City of Portland, Maine - Building or Use Permit Application

Permit No: 03-1453	Issue Date: JAN 26 2004	CBL: 153 A025001
-----------------------	----------------------------	---------------------

Past Use: 33 Unit PRUD	Proposed Use: Units 27-33 of 33 unit PRUD	Permit Fee: \$7,638.00	Cost of Work: \$813,000.00	CEO District: 4
---------------------------	--	---------------------------	-------------------------------	--------------------

Dept: Building **Status:** Approved with Conditions **Reviewer:** Mike Nugent **Approval Date:** 01/22/2004
Note: **Ok to Issue:**

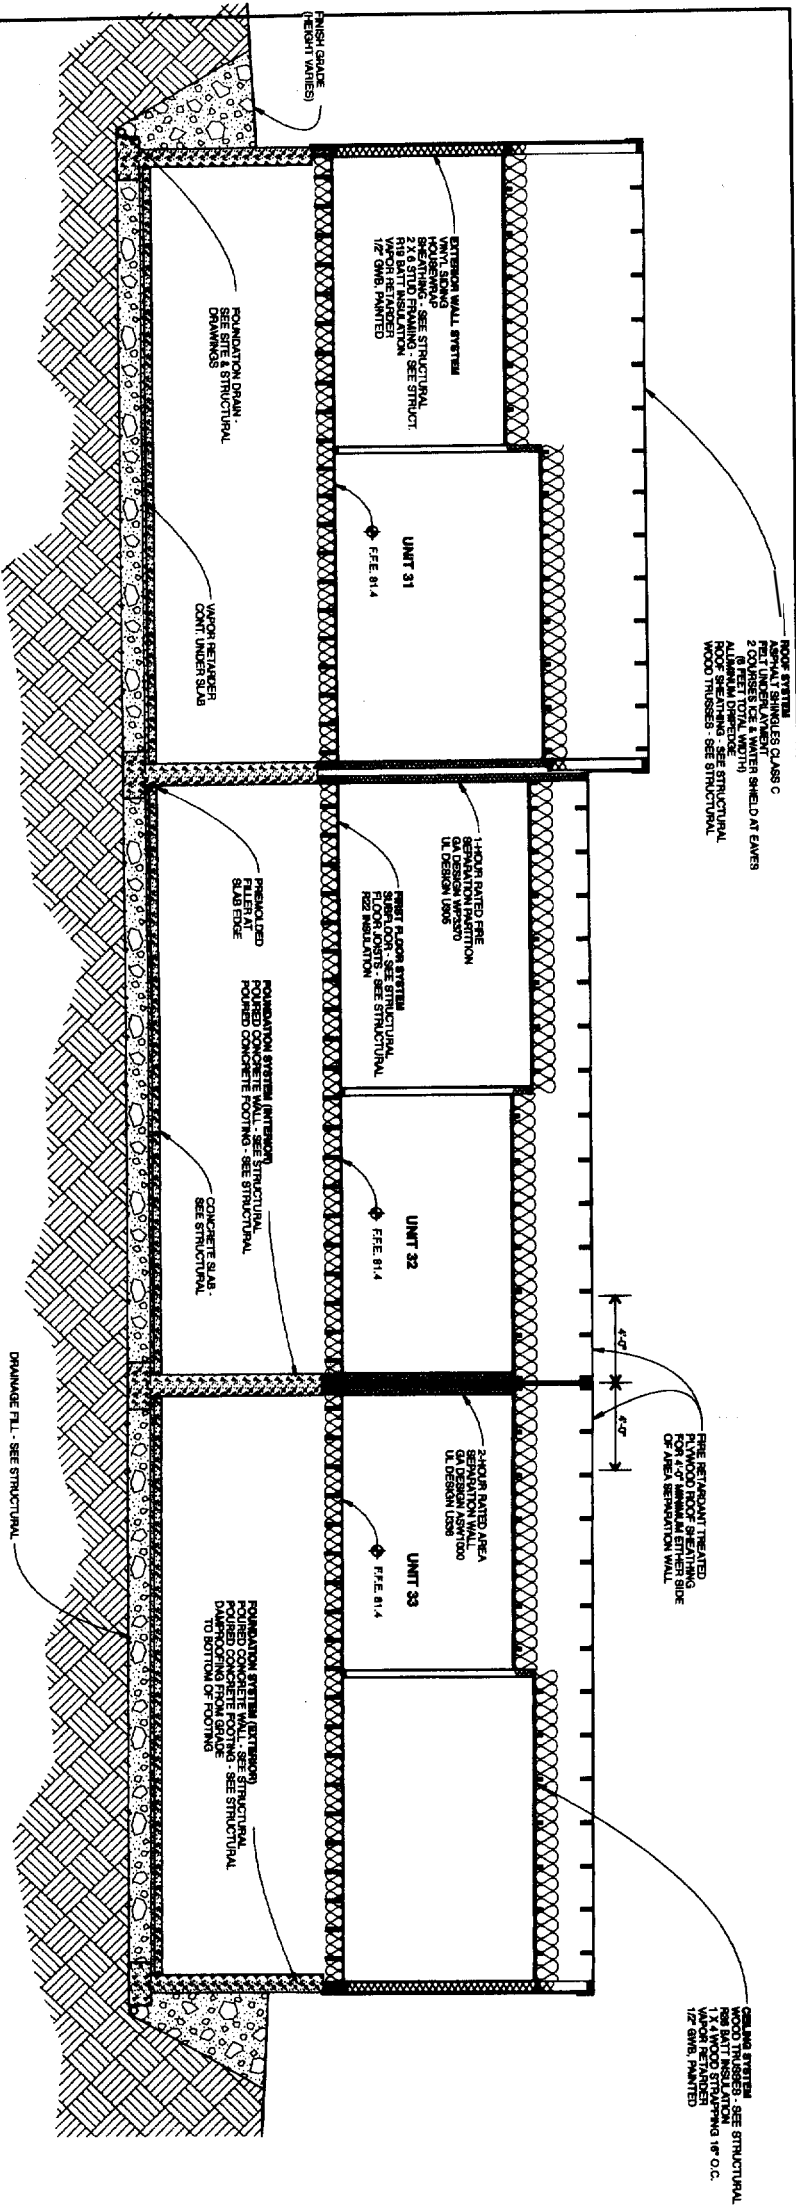
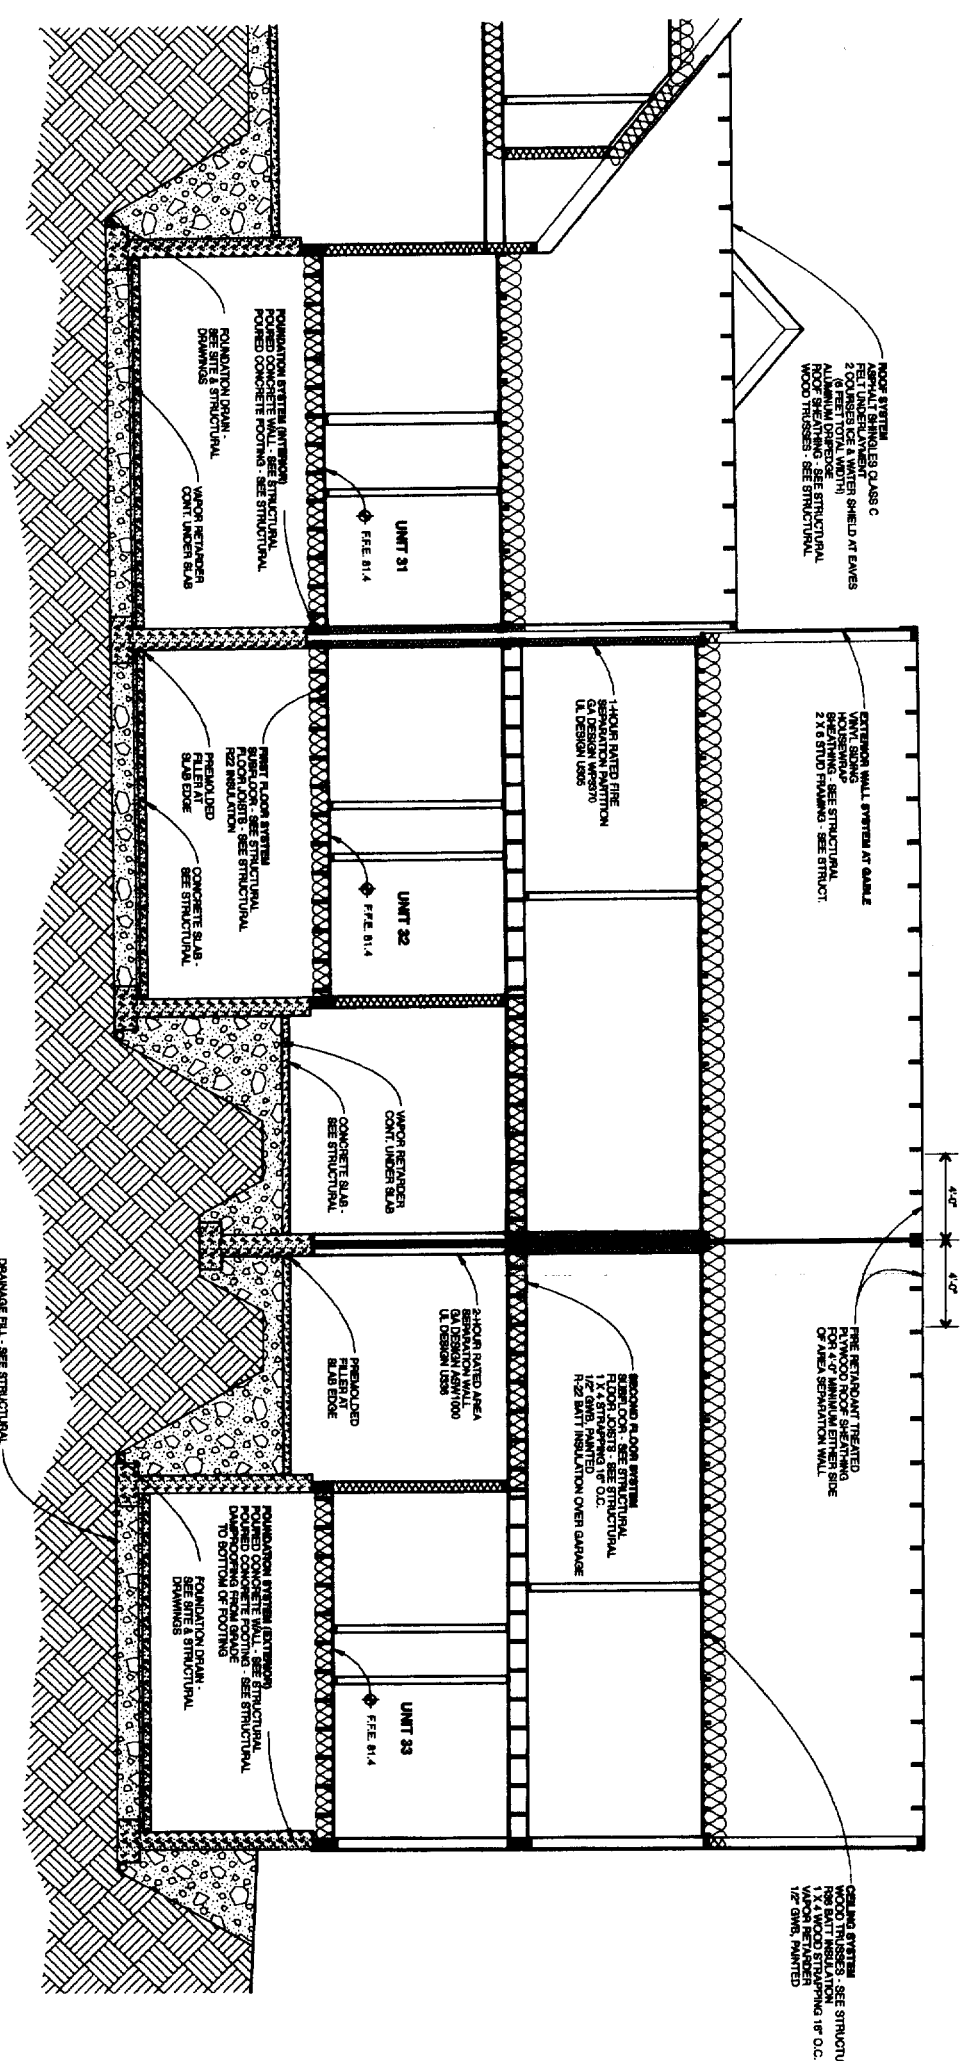
1) Need information on guards and fire separation assembly clarification on page A313, Mike Charek has agreed permit released with this condition.
